**Turf Masters LLC  
Variance of Use  
Letter of Intent**

**November 20, 2024**

PDC File No. VA248

TURF MASTER VARIANCE OF USE

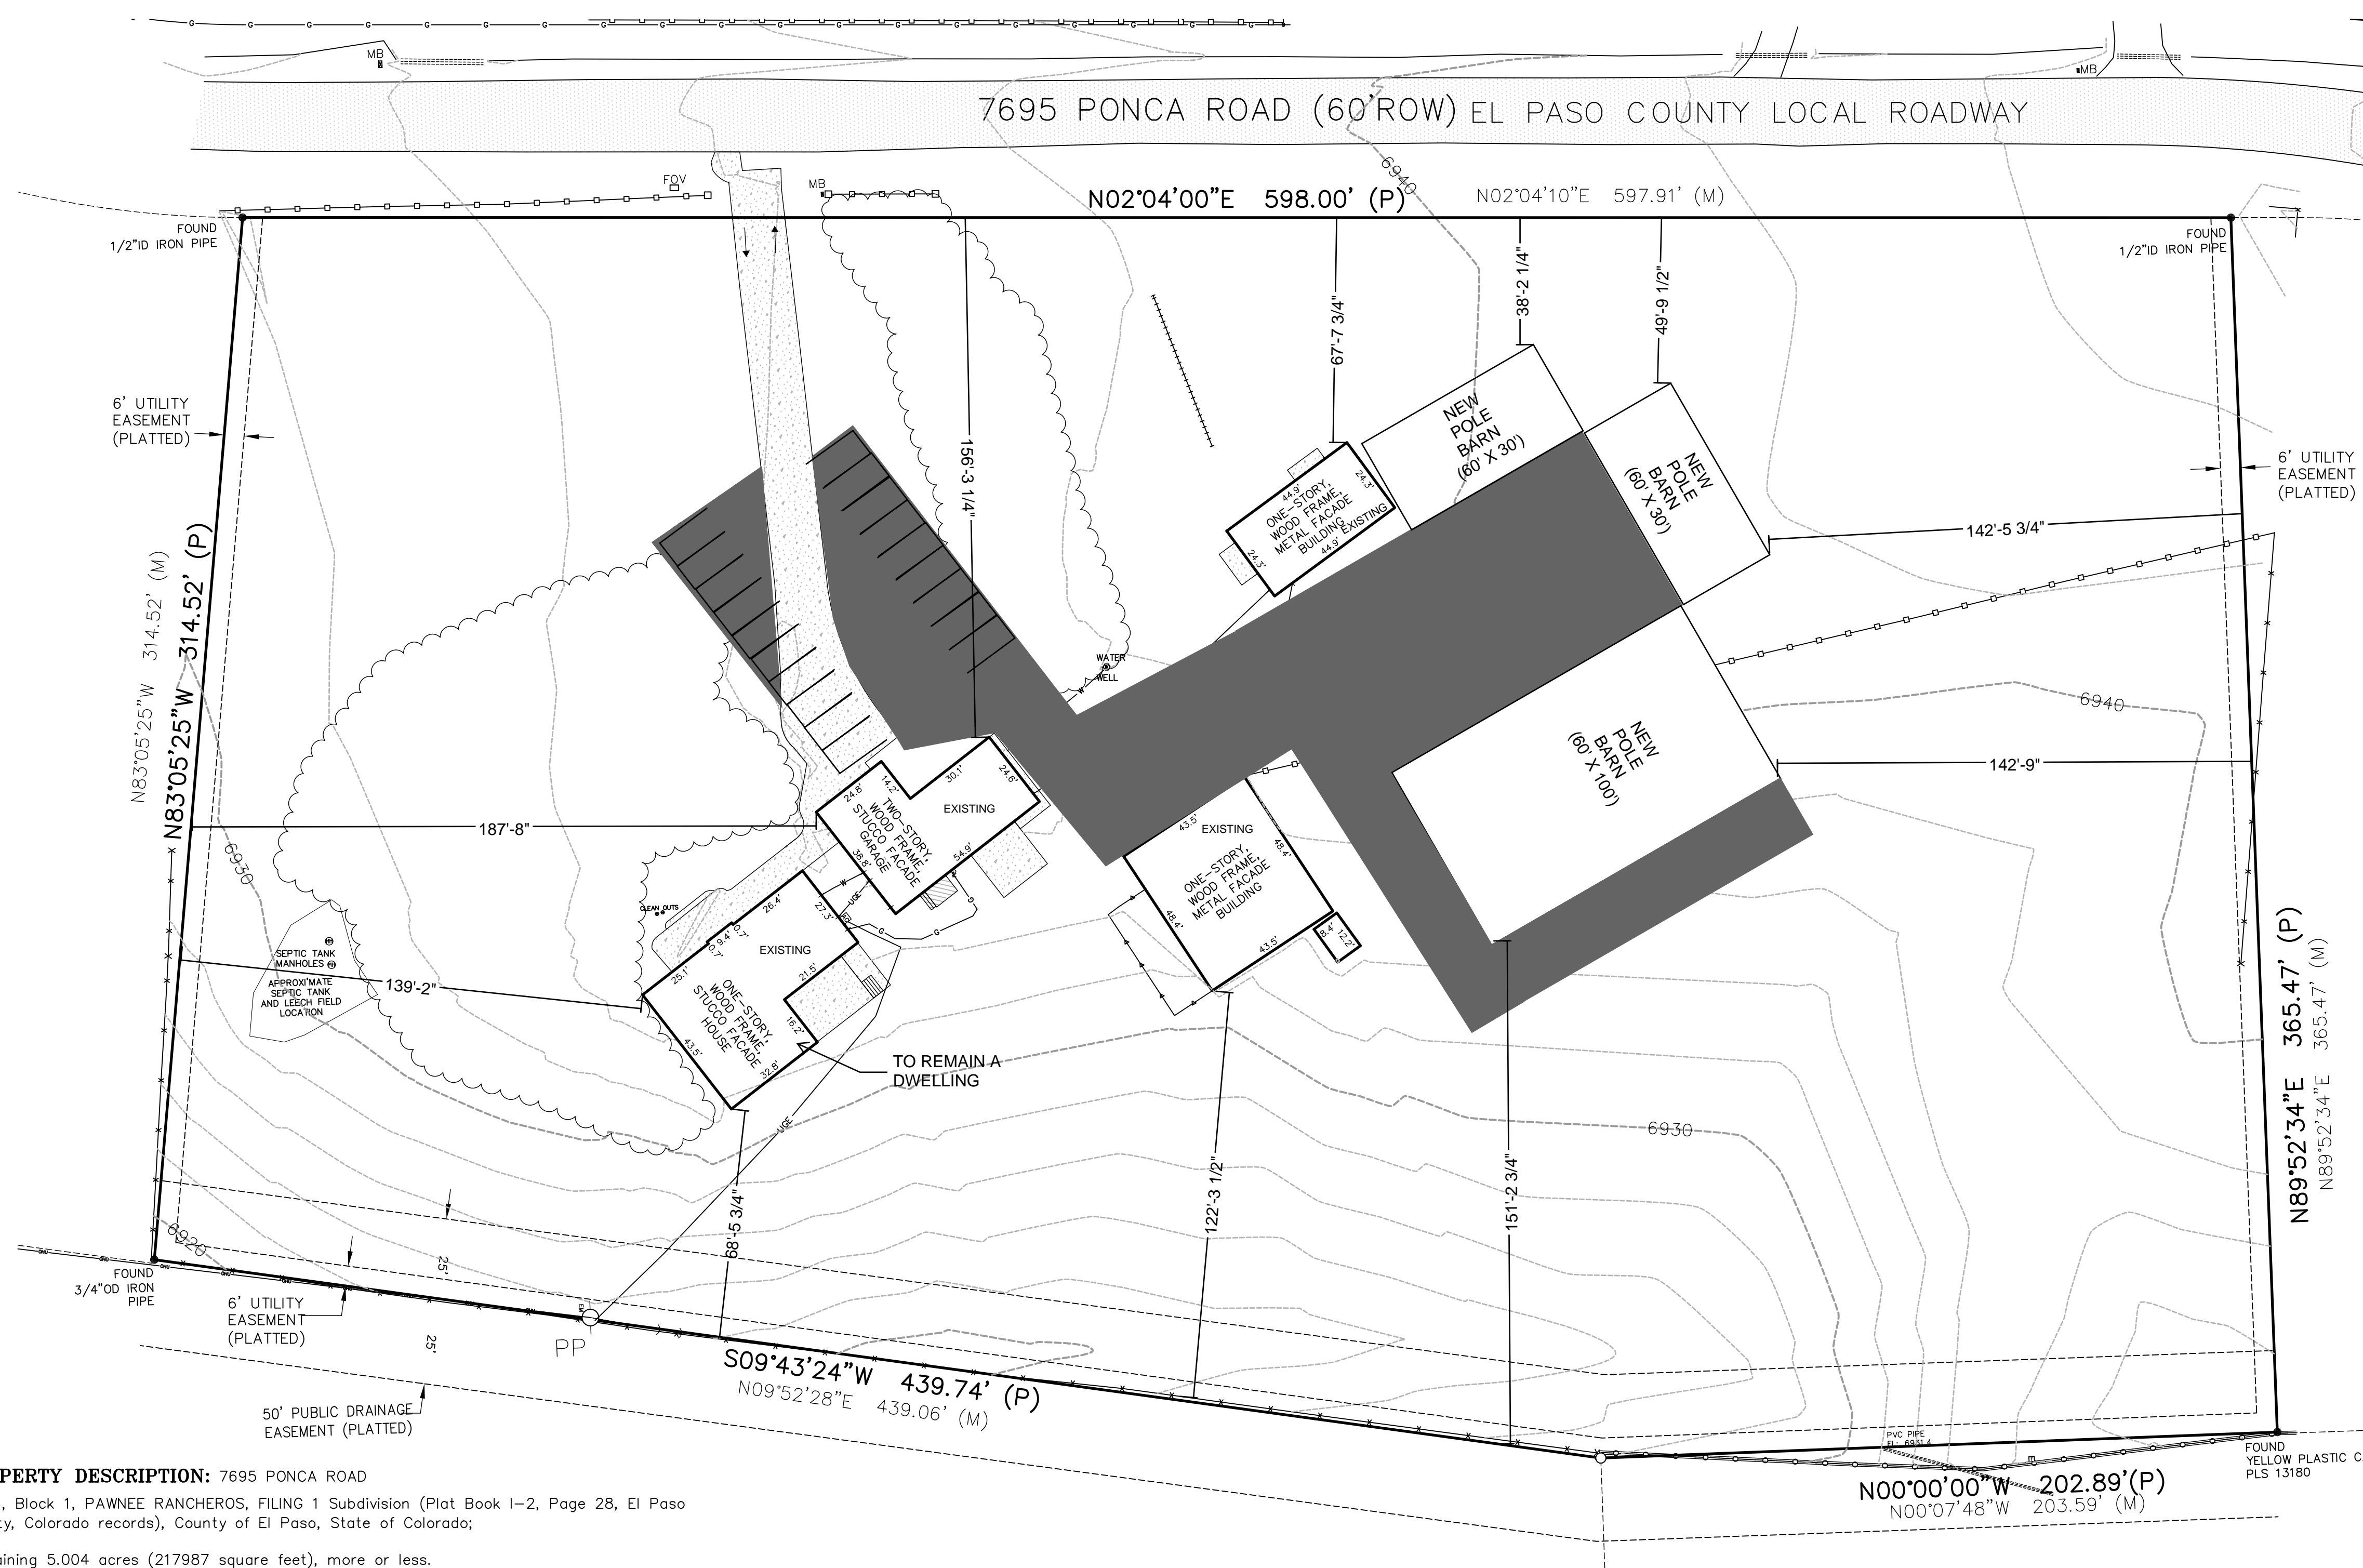
Review 1 comment: Inconsistent with site plan

Review 2 comment: Unresolved, still inconsistent with site plan.

Review 1 comment: Inconsistent with site plan  
Review 2 comment: Unresolved, still inconsistent with site plan.

The total of the three structures is 9,600 SF, which equates to 18.34 [18] parking spaces being required. There are three other existing accessory structures totaling 4,162 square feet,

three other existing accessory structures totaling 4,162 square feet, which equates to 20 parking spaces being required. There are three other existing accessory structures totaling 4,162 square feet, which equates to 20 parking spaces being required.

20 parking spaces
